25 September 2018

Environmental Assessment – Pipers Flat Rail Coal Unloader (06_0271 MOD 1)

MALCOLM HUGHES Manager Catchment Protection

Figure 2 | Approved (black) and Proposed (pink and red) Rail Loop and Conveyor

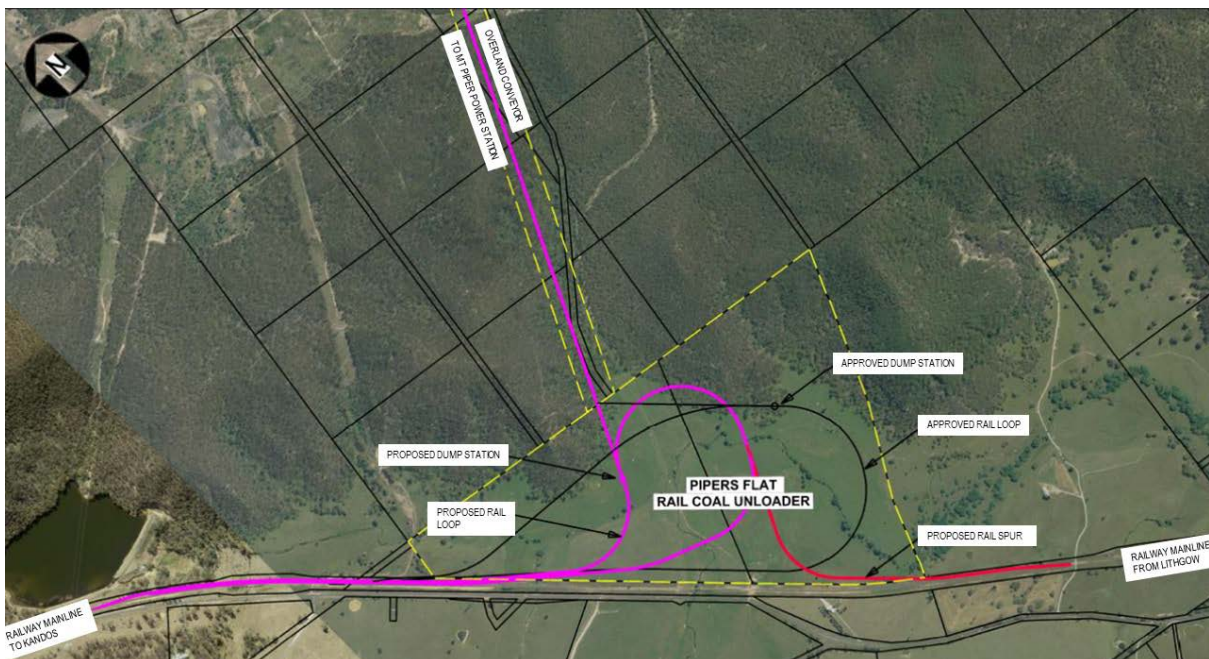
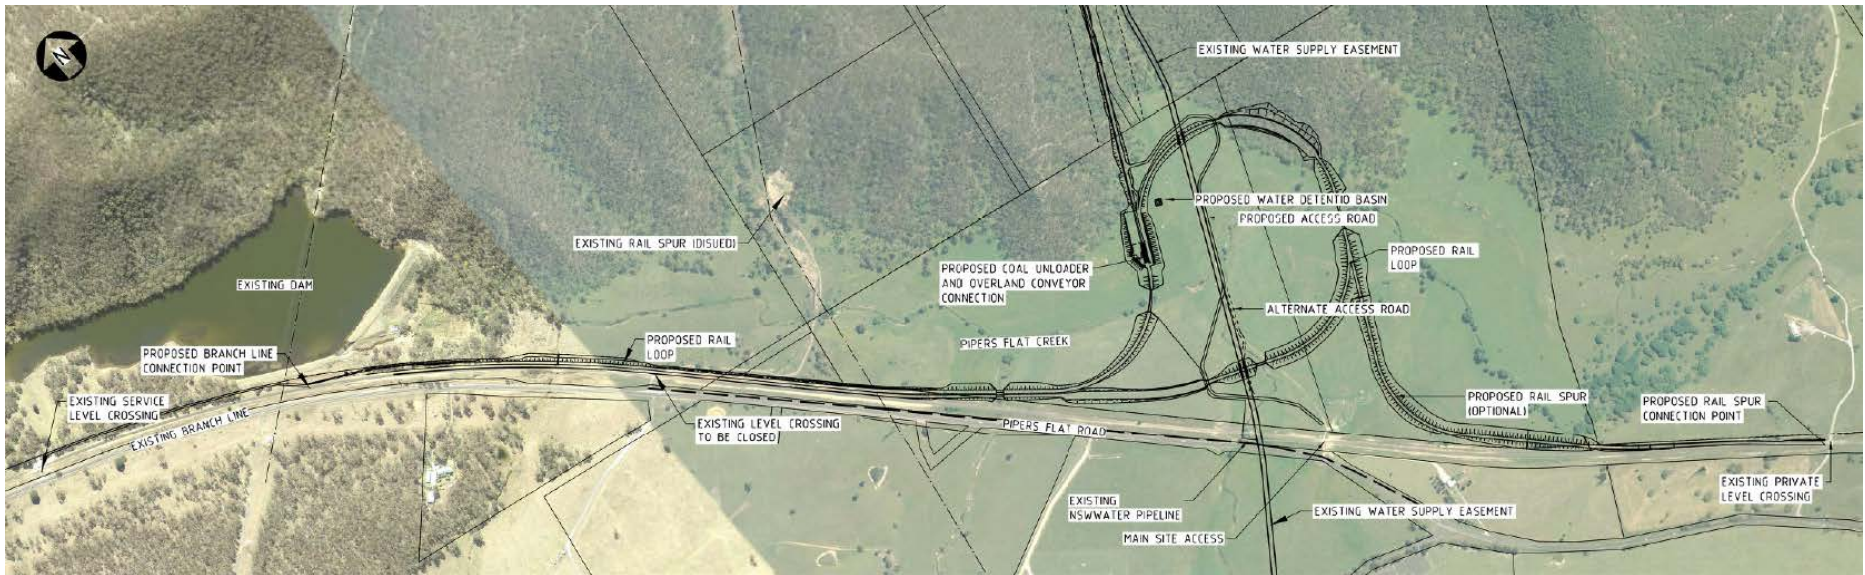
WaterNSW notes that Fish River water supply pipelines to Mount Piper power station and Portland township underlies the proposed rail loop area and located along Pipers Flat road reserve respectively. WaterNSW considers that the detailed design of the rail loop; creek crossings and access road to the coal unloader building should be prepared in consultation with WaterNSW and that considerable care is required during detailed design and construction:

- for the crossings of Pipers Flat Creek, Thompsons Creek, Irondale Creek, Winters Creek and access road to coal unloader building to minimise scouring of these waterways, and
- to provide protection during construction and 24 hours access during operations of the project to the Fish River water supply pipelines.
